**Re: Sawmill Building A at 1904 Bellamah Ave NW  
Erosion and Sediment Control Plan  
Engineer's Stamp Date 2/3/25 (J13E044A) SWQ-2025-00016**

Based on the information in your submittal received on 3/12/25, the ESC Plan can't be approved until the following comments are addressed.

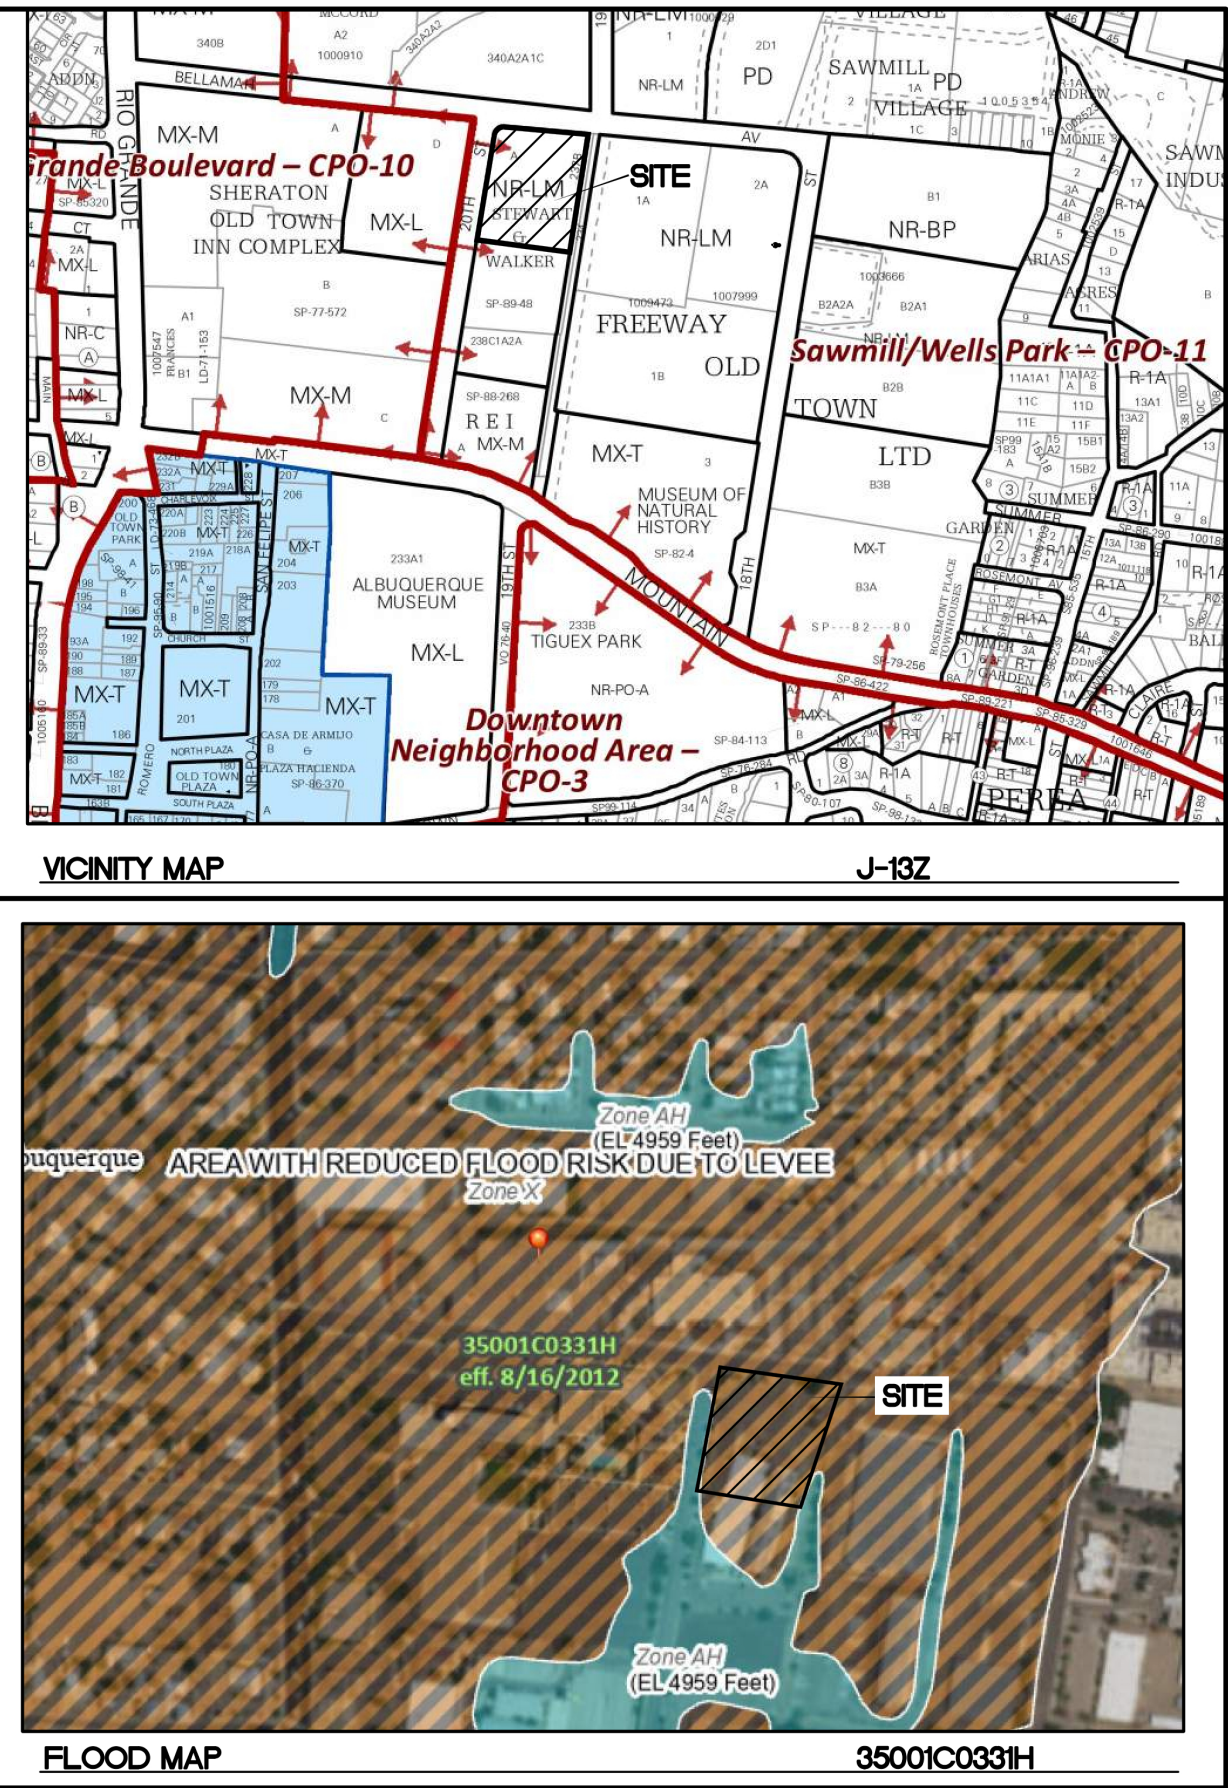
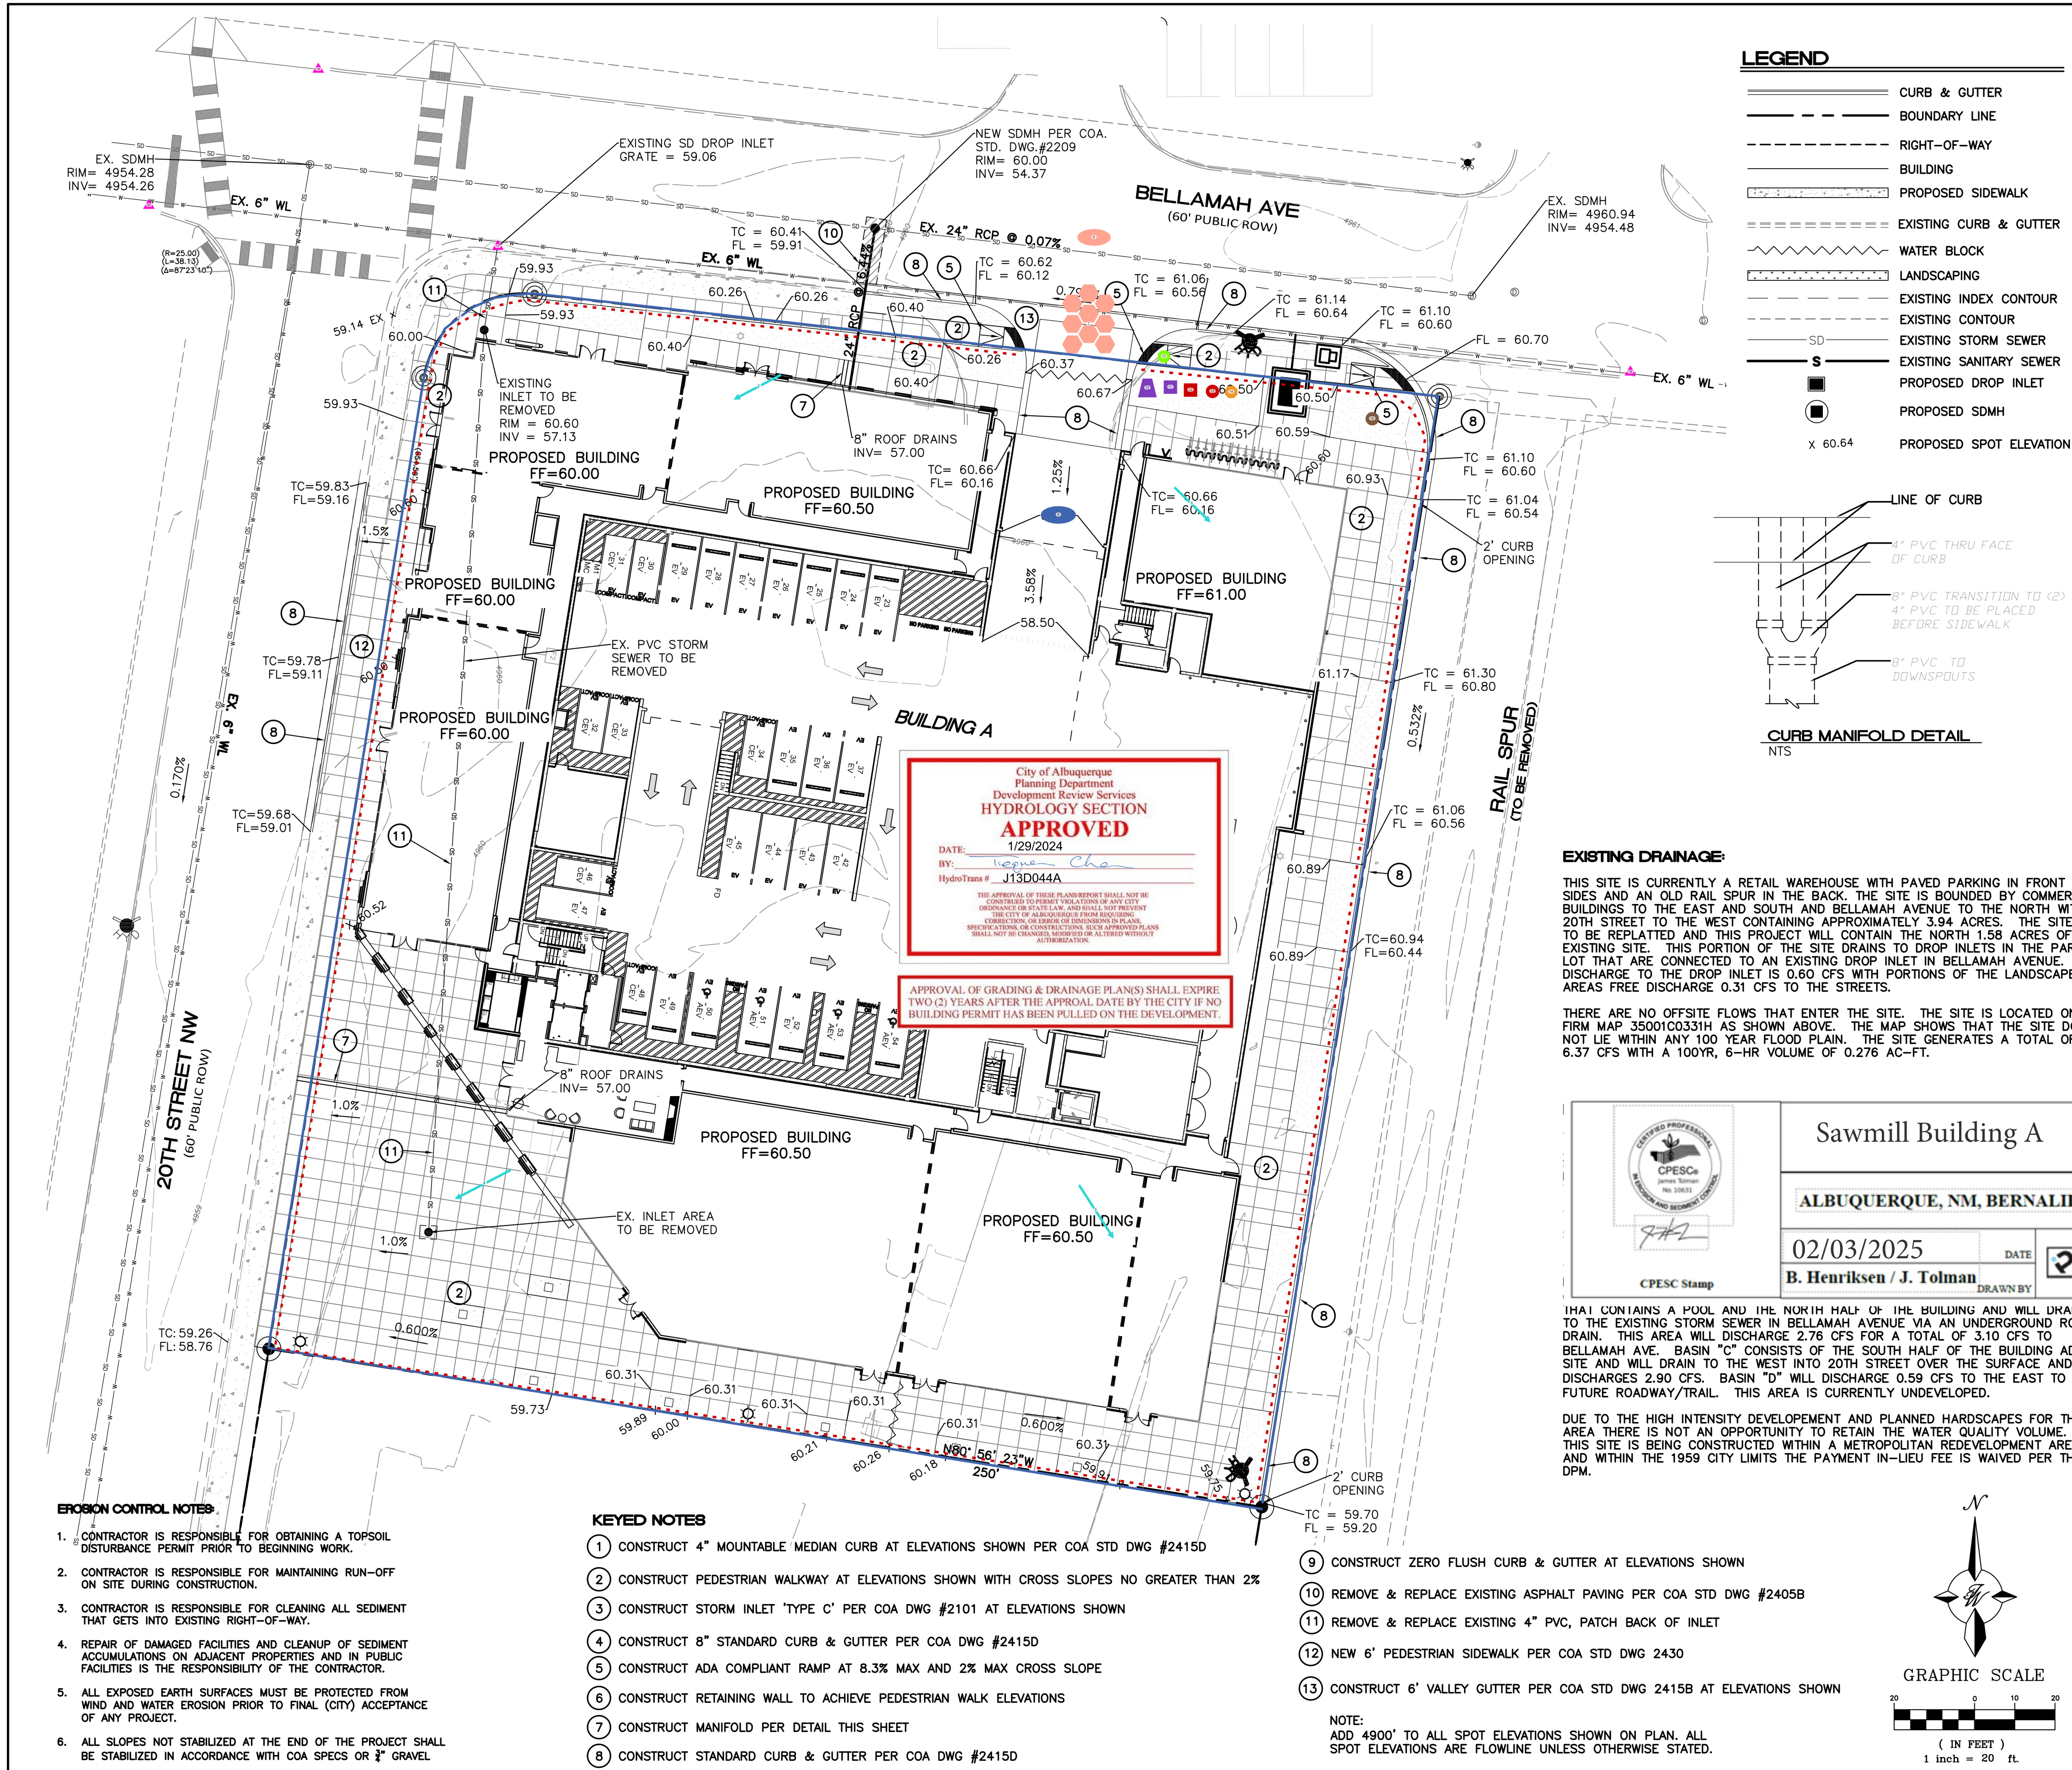
3. The estimated area of disturbance is incorrectly shown as 1.75 acres on the NOI and 1.58 acres on sheet 2 of the ESC Plan, but the demolition plan calls for the demolition of the entire 3.9-acre site.
